# MORGAN AND MORECAMBE OFFSHORE WIND FARMS: TRANSMISSION ASSETS

## Street Works Plan- Part 1 of 2

8 August 2025  
Rev: F02

PINS Reference: EN020028  
APFP Regulations: 5(2)(k)  
Document reference: B12/F02

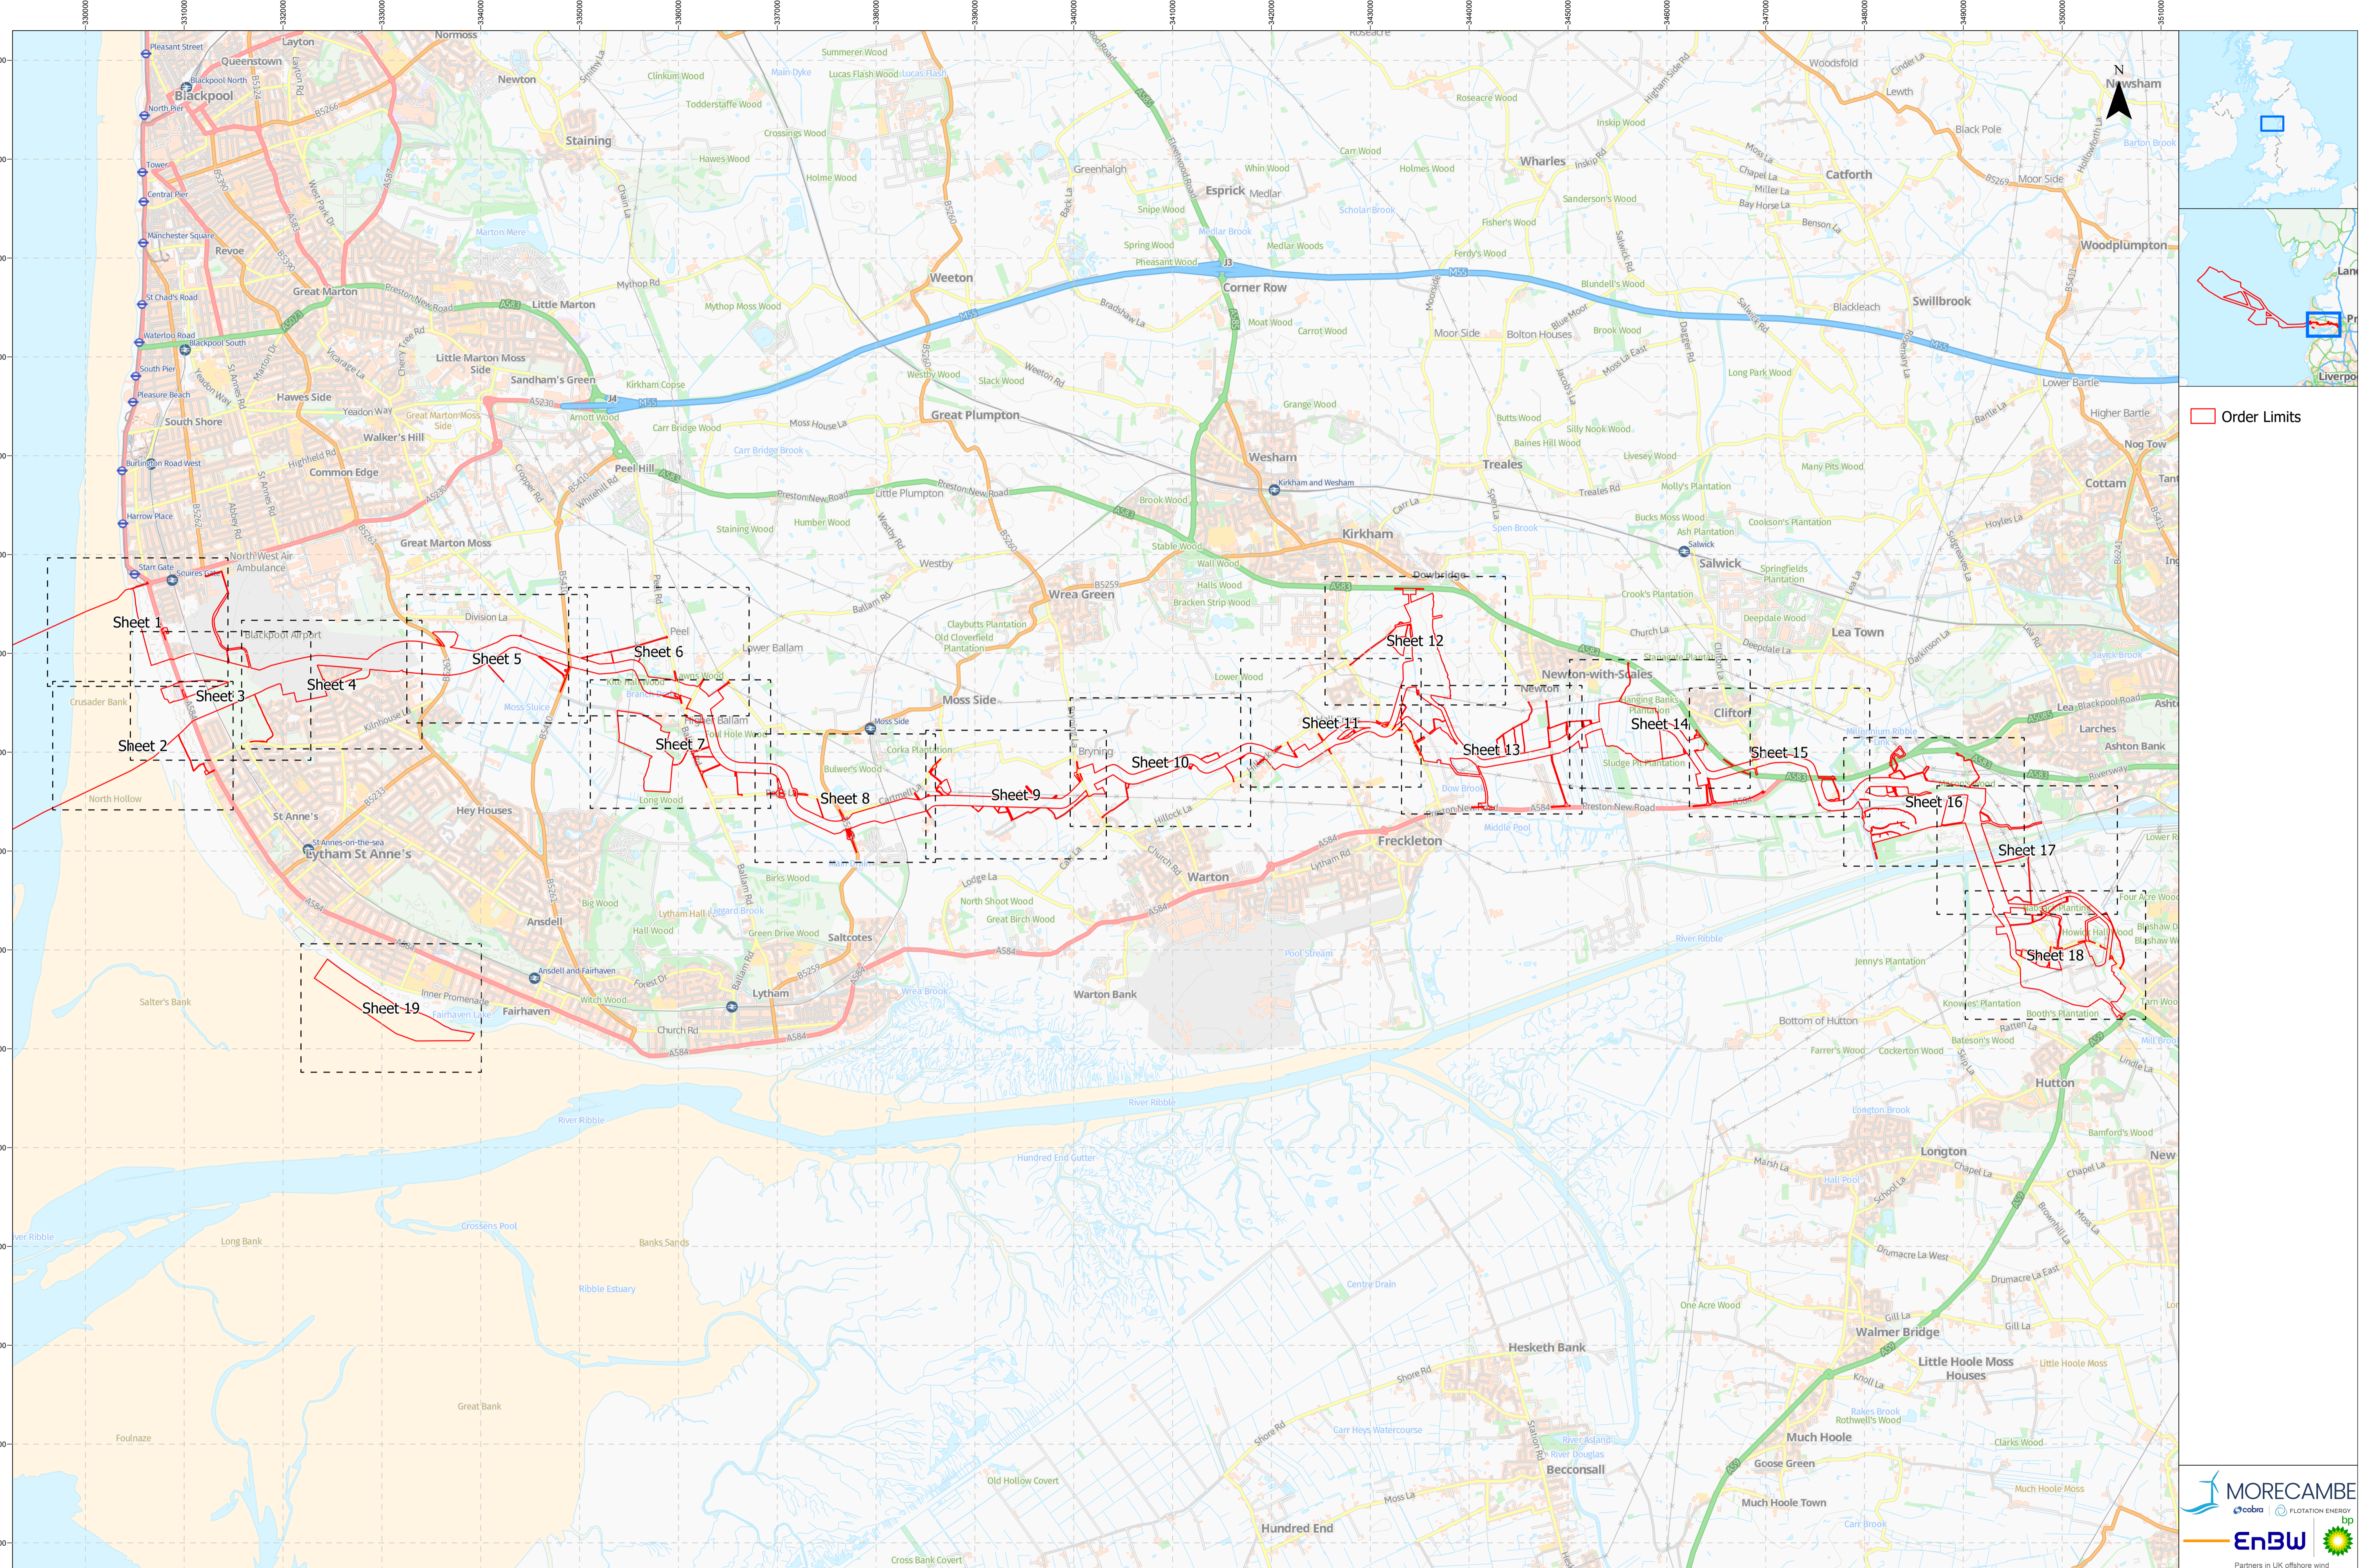
Sheet Number	Change requested by	Change Made	Reason for Change	Revision	Submission deadline
1	Blackpool Borough Council	Removal of extents on Squires Gate Lane between points MGMC_HA_1A and MGMC_HA_1B; Private Access between points MGMC_PA_1A and MGMC_PA_1B; and on Squires Gate Lane between points MGMC_HA_35A and MGMC_HA_.	To address points raised in discussion with Blackpool Borough Council via the Statement of Common Ground process to remove powers within the draft Development Consent Order (document reference C1) associated with Starr Gate and the access into Blackpool Airport via Squires Gate Lane.	F02	Deadline 4
